CITY OF ALBUQUERQUE

**Re: MCT Industries Paint Booth Replacement, Grading and Drainage Plan,
Engineer's Stamp Dated 11-07-2011 (D17/D047)**

Based upon the information provided in your submittal dated 11-08-2011, the above referenced plan can not be approved for Building Permit until the following comments are addressed:

GRADING and DRAINAGE PLAN

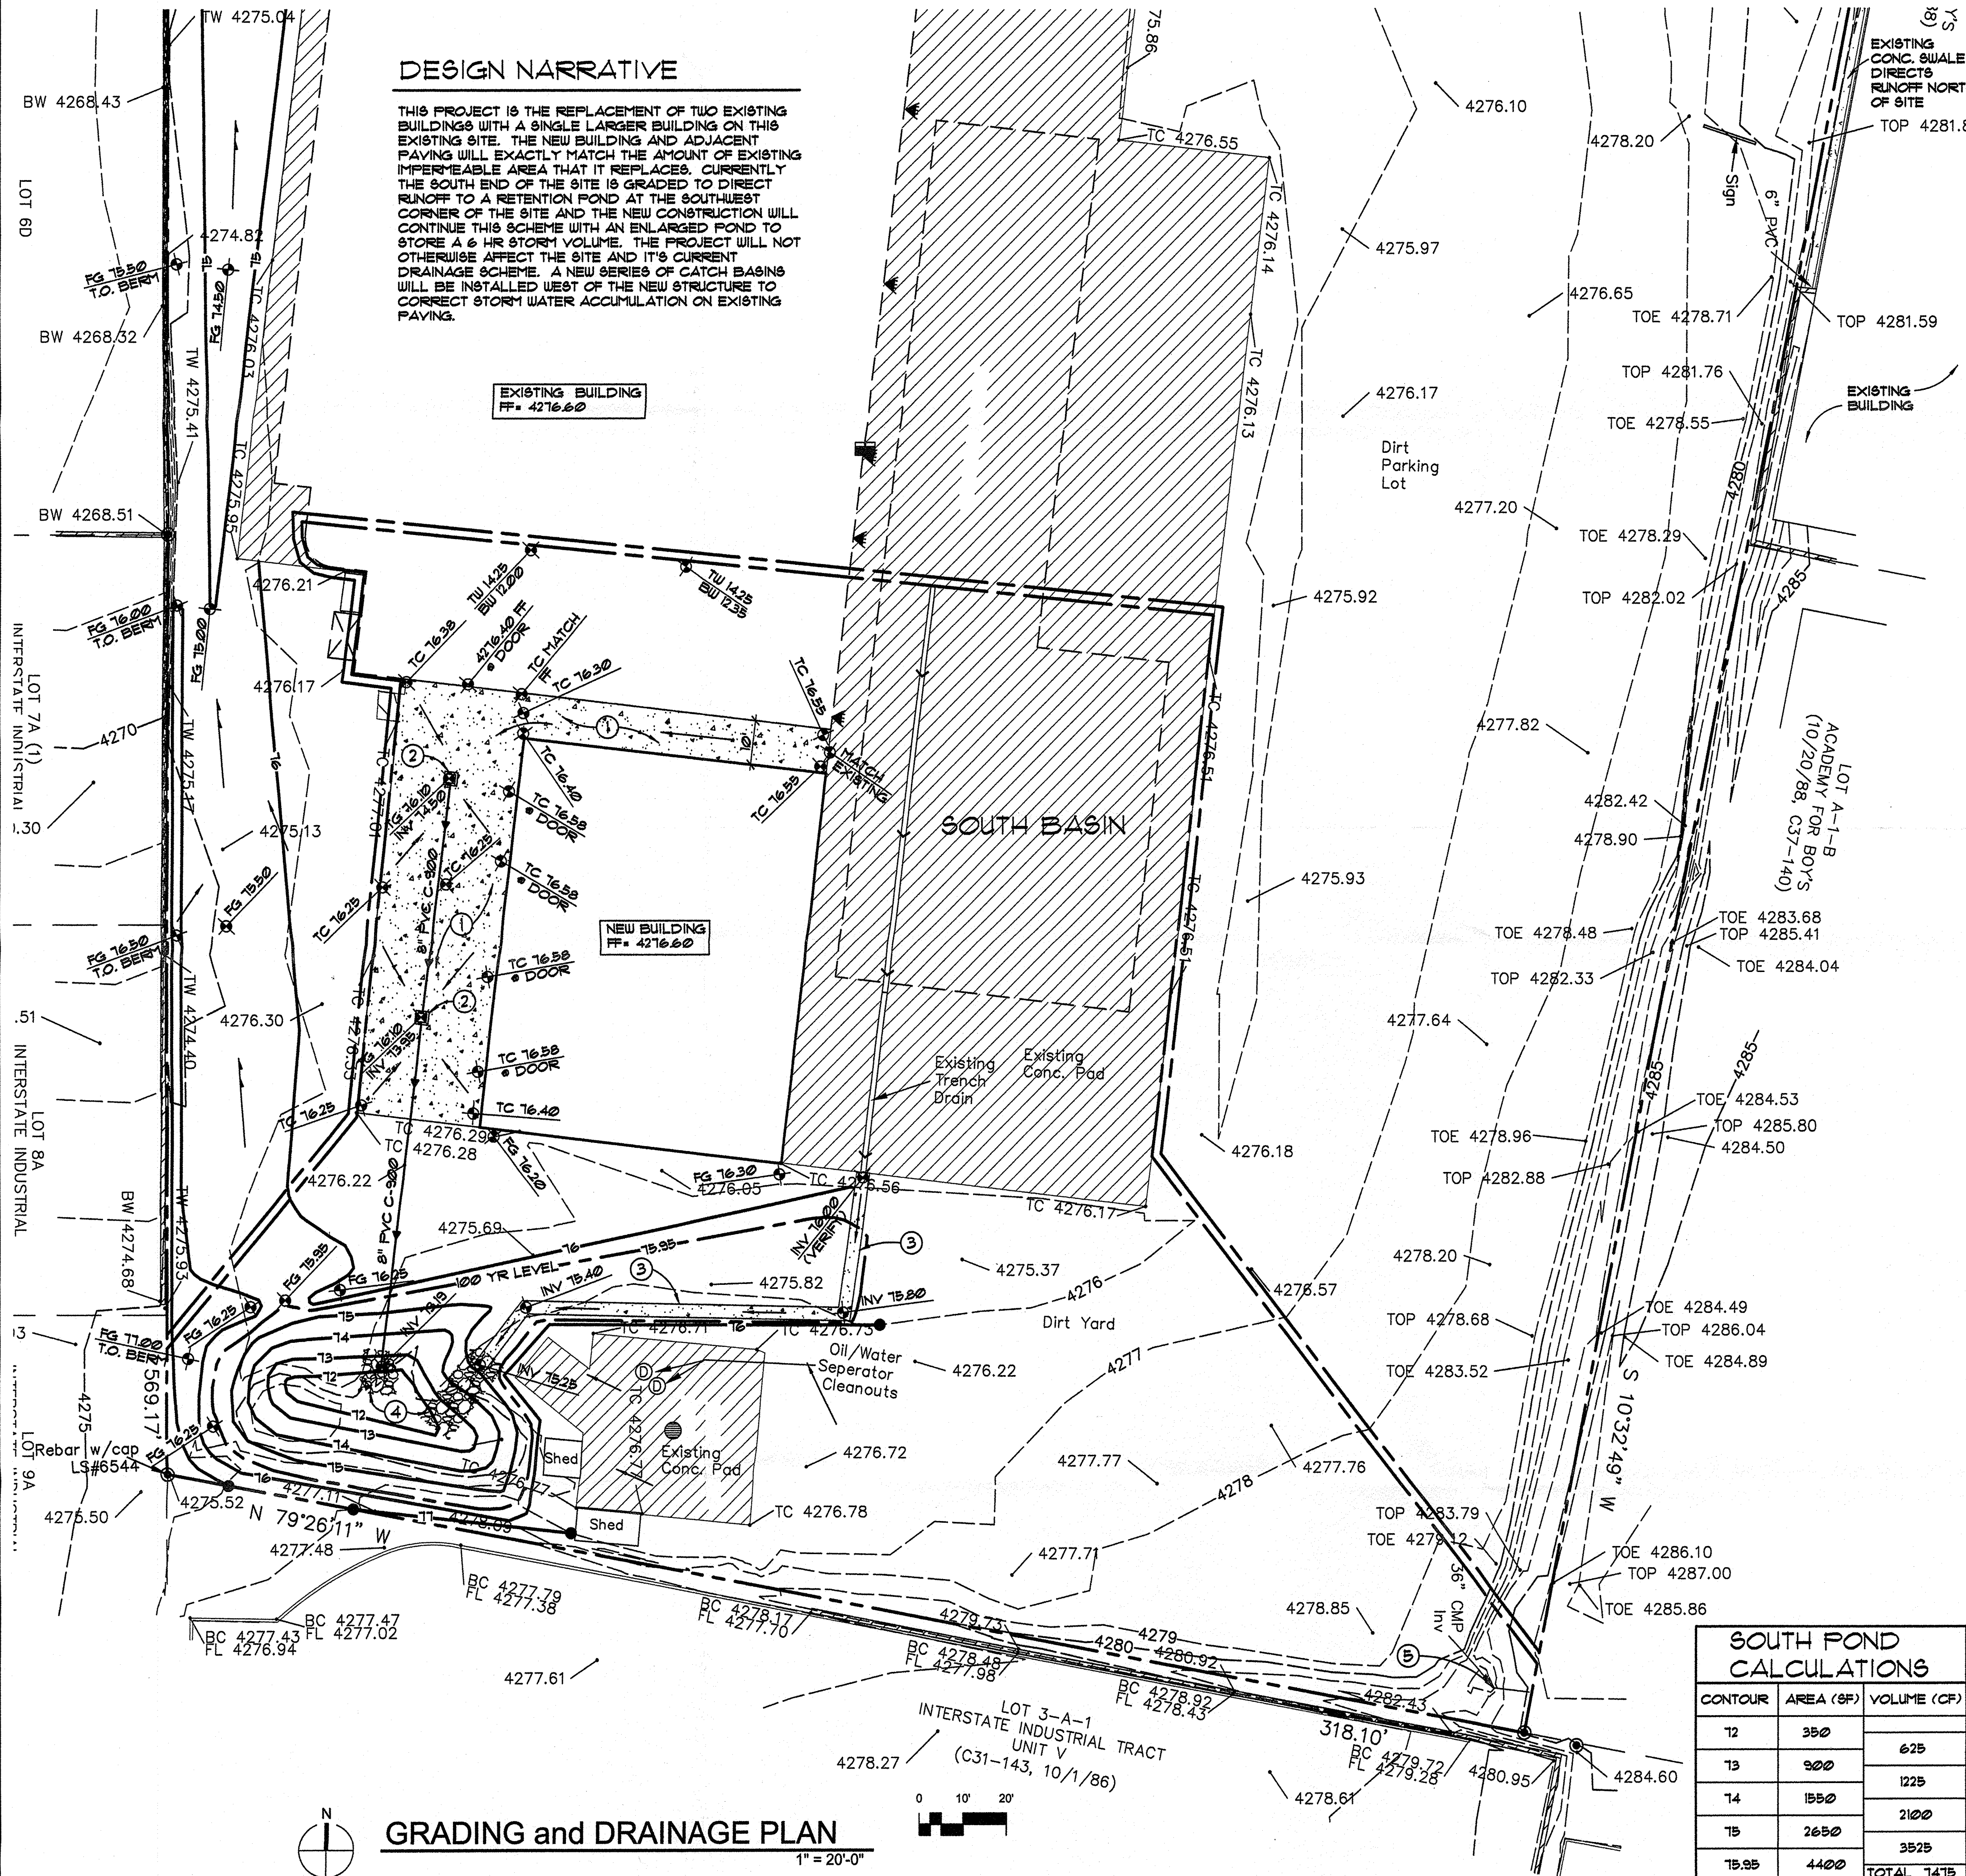
- Include all the offsite runoffs and explain how it will impact this site.
- Provide proposed pond calculations. Show the 100-Yr WSEL. Provide emergency overflow and calculations.

- Are there any slope protection being proposed for the pond at the end of the valley gutter and the 8" pipe.
- The top of pond elevation is "FG 79.90" next to a proposed contour with an elevation of 76.00. Please correct this elevation.

- There is existing hatch area to the east of the retention pond. Please note on the plan what this area is and were to and how does it drain.
- Another hatch area is shown on the east side of the building. Please indicate what this hatch area is.

- There is an area just west of the new building where the runoff ponds against the existing wall. Will this area be regarded?
- Does the pond to the north have adequate volume for the existing developed runoff for the northerly portion of this site?
